CITY OF ALBUQUERQUE

July 29, 2021

Re: JB Henderson Fabrication Facility
10200 Bell Ave. SE
Traffic Circulation Layout
Architect's Stamp 01-15-2021 (L20-D075)

AS-101

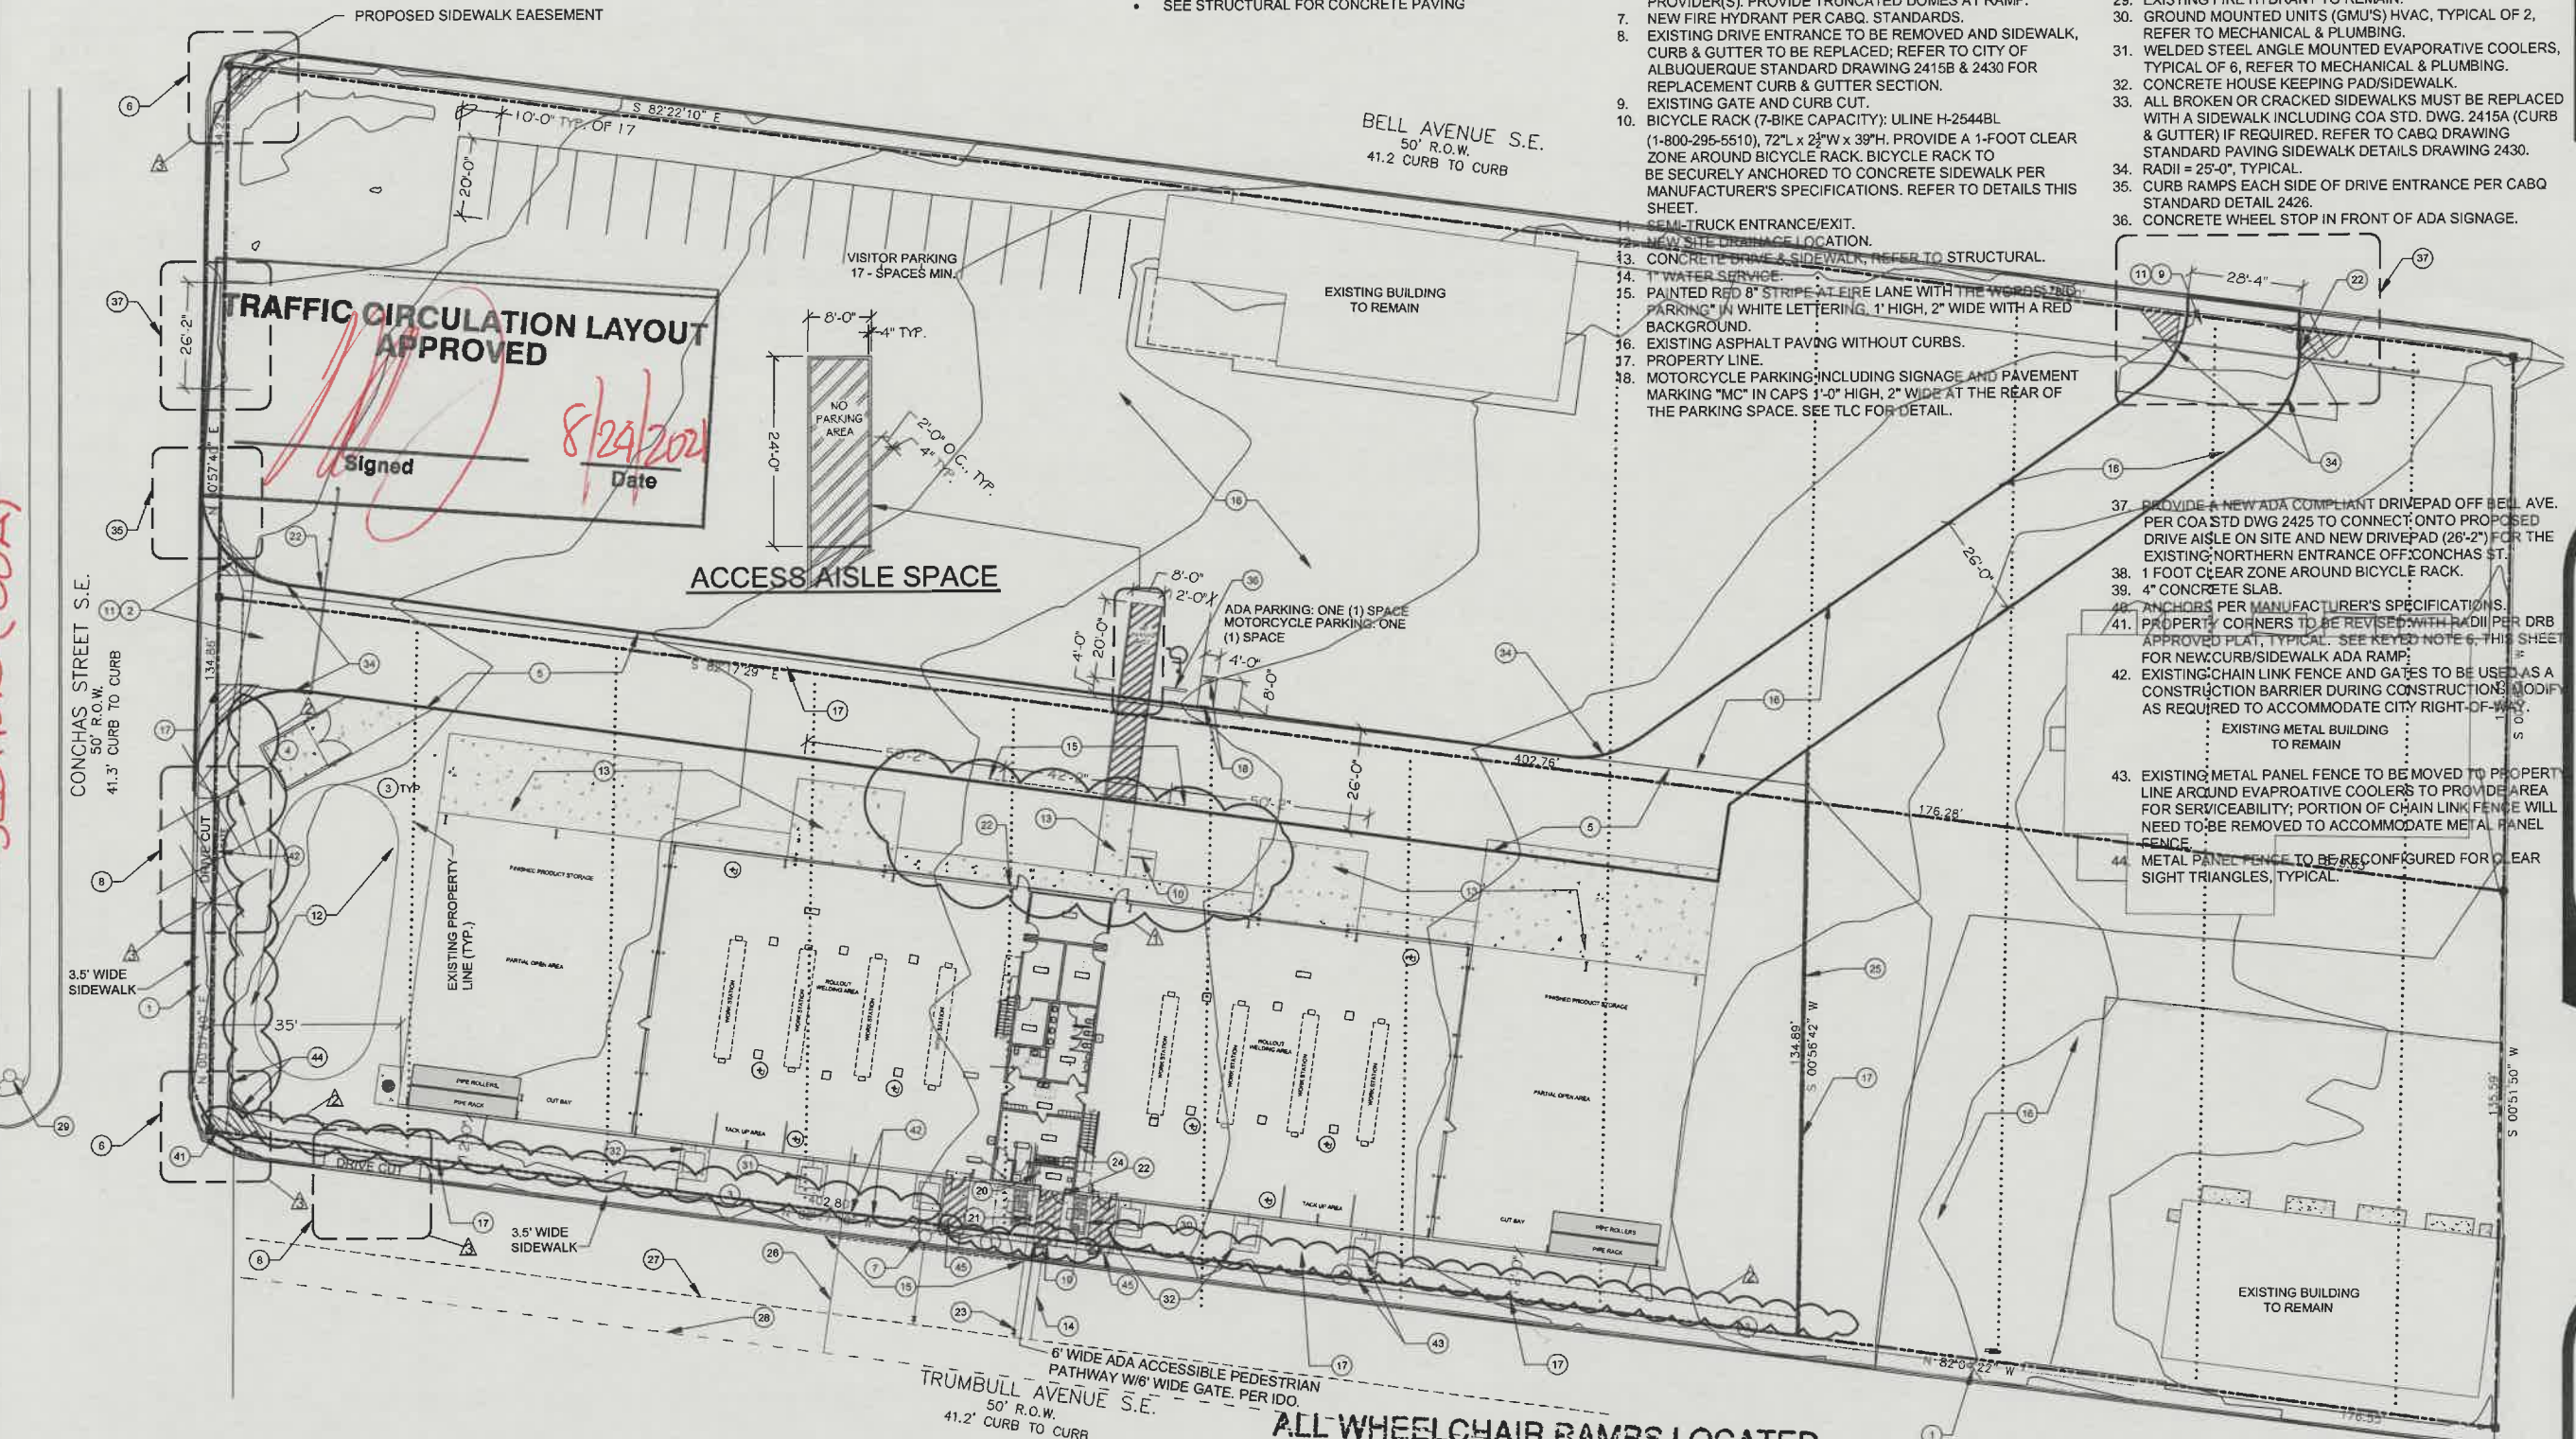
2. **Sheet AS-101:** If are referencing CIVIL. So, provide CIVIL sheet as part of the submittal.

TCL

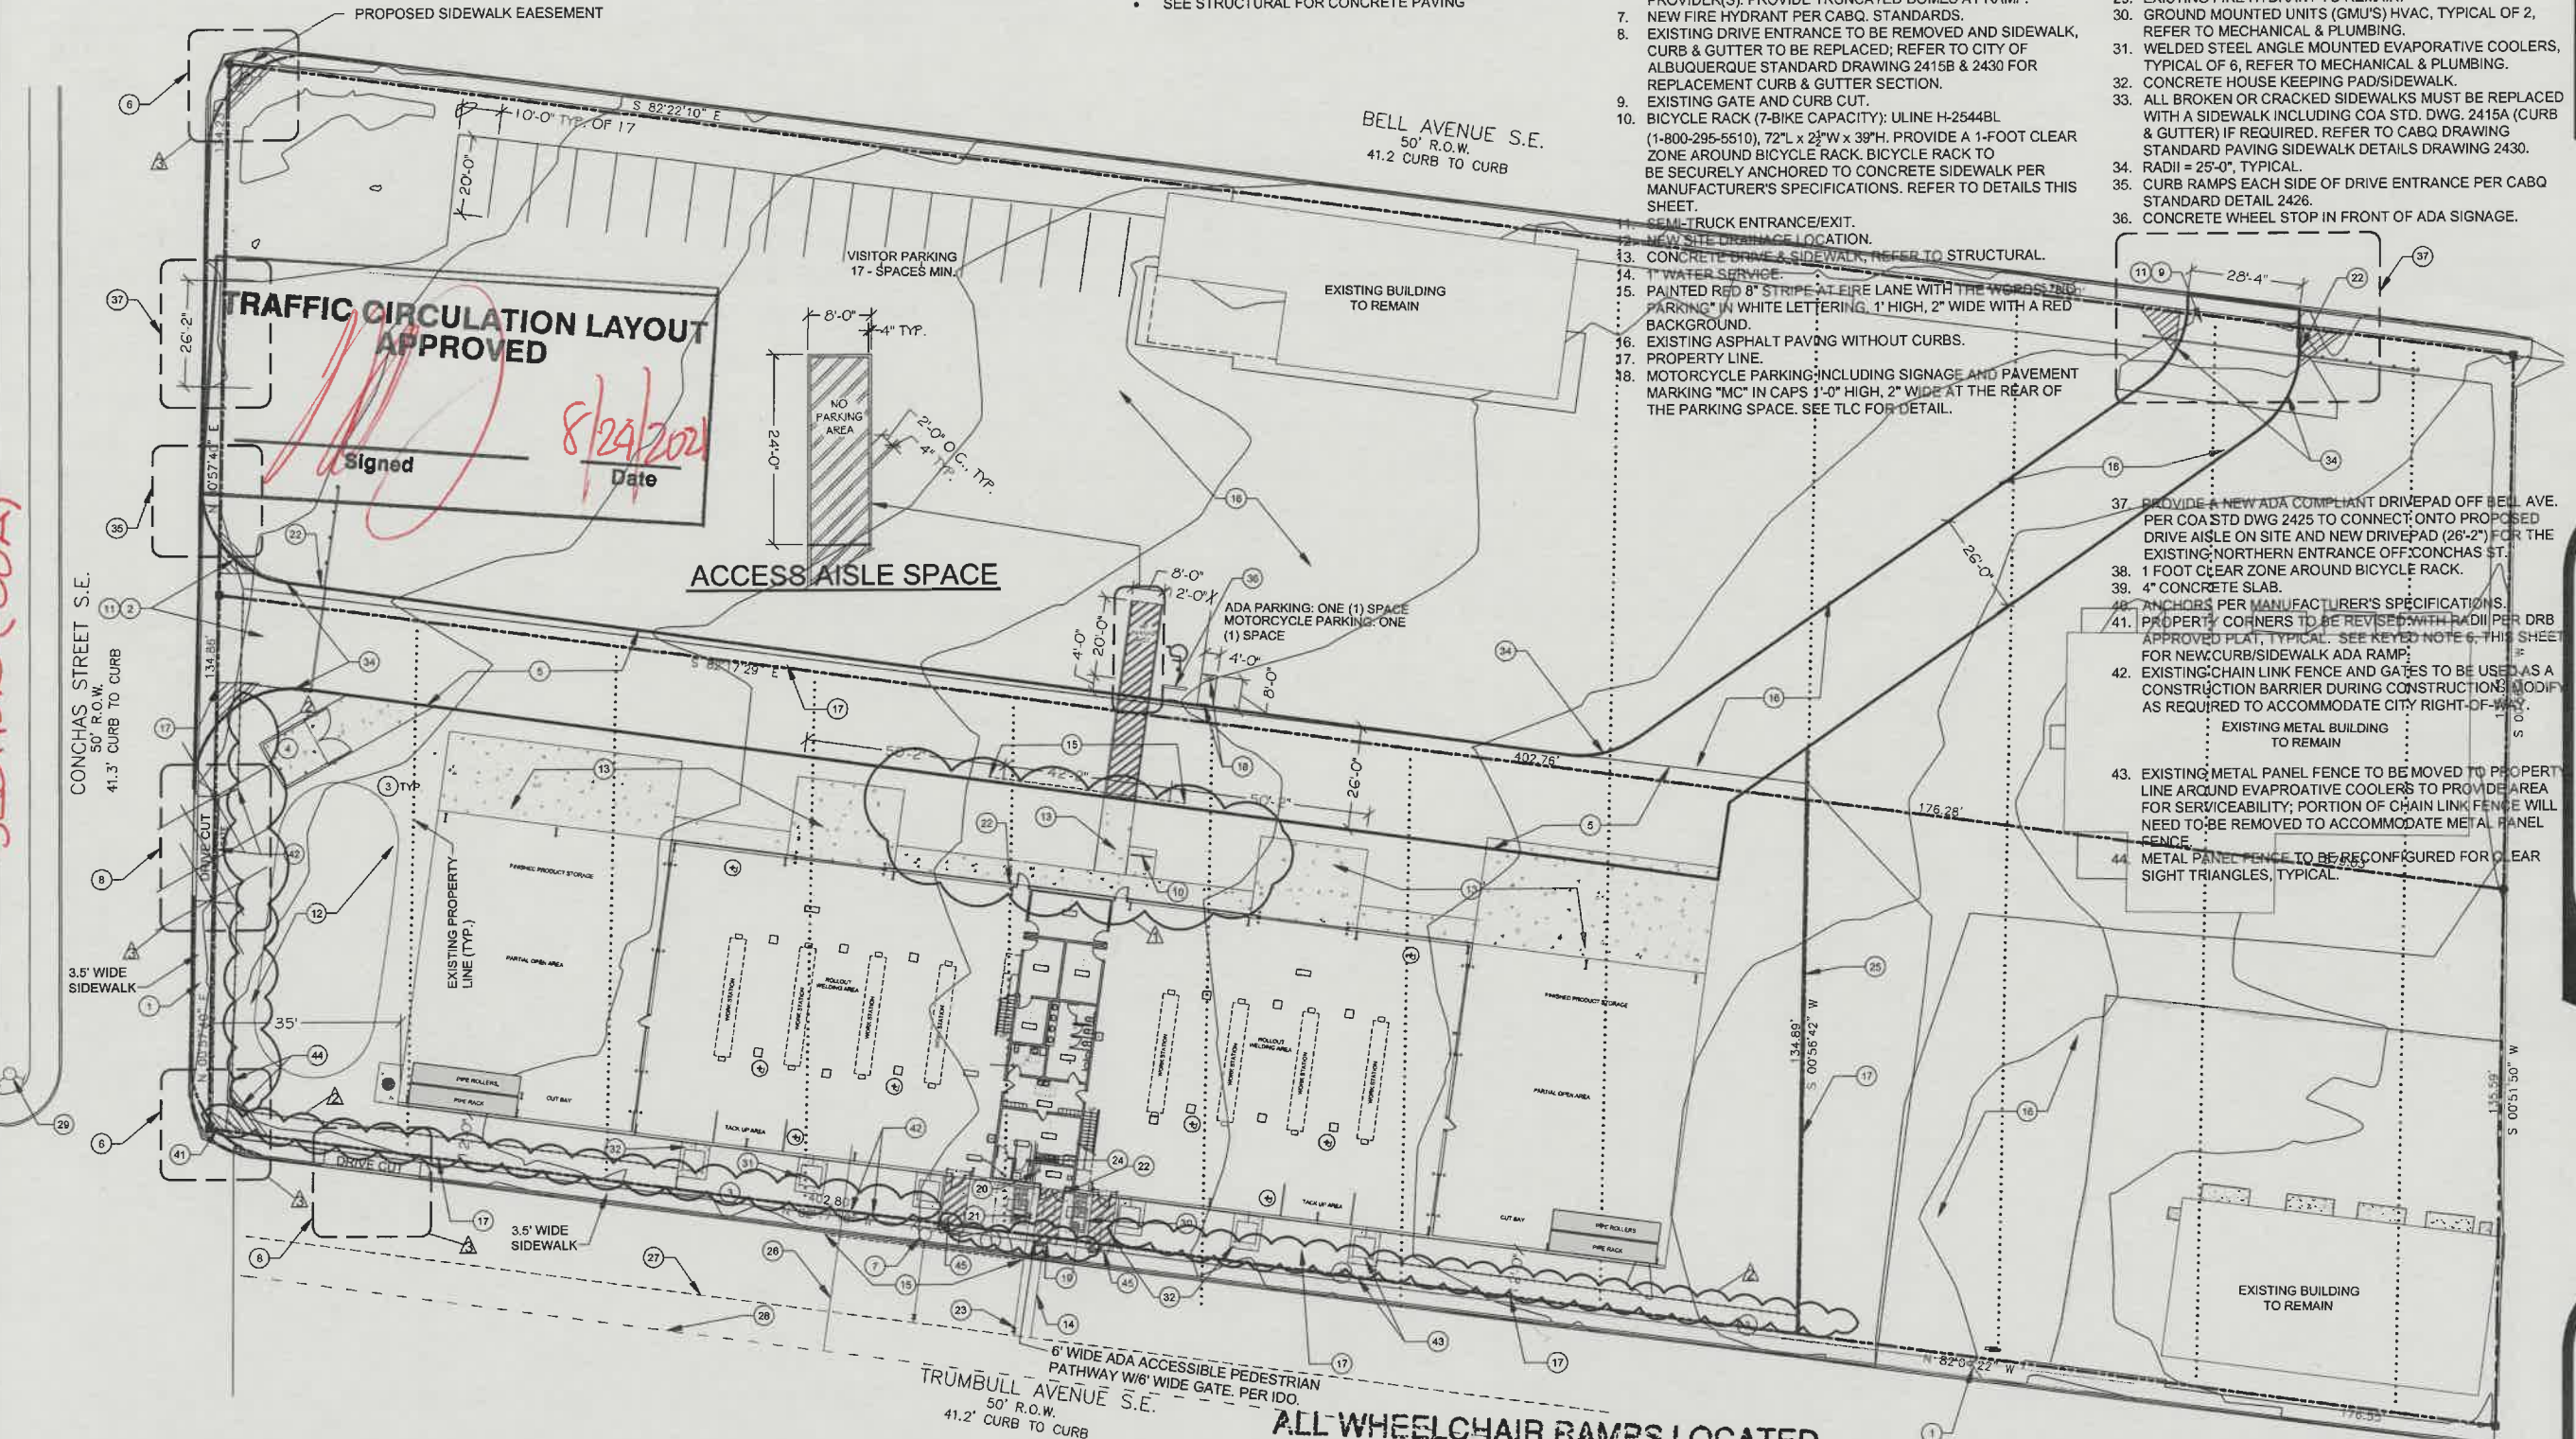
1. **Bell Ave/ Conchas Corner:**

- The approved PLAT doesn't show this radii at the corner. So, why are you providing this radii?
- A Sidewalk Easement will be needed at this corner to provide an appropriate ared for the proposed ADA ramp. See Attachment for sidewalk easement.

4. **6 ft. wide ADA accessible pedestrian pathway** is shown on TCL plans, are there any gates that will compromise the 6 ft width or will a 6ft wide gate be provided for the 6 ft pathway? Please elaborate
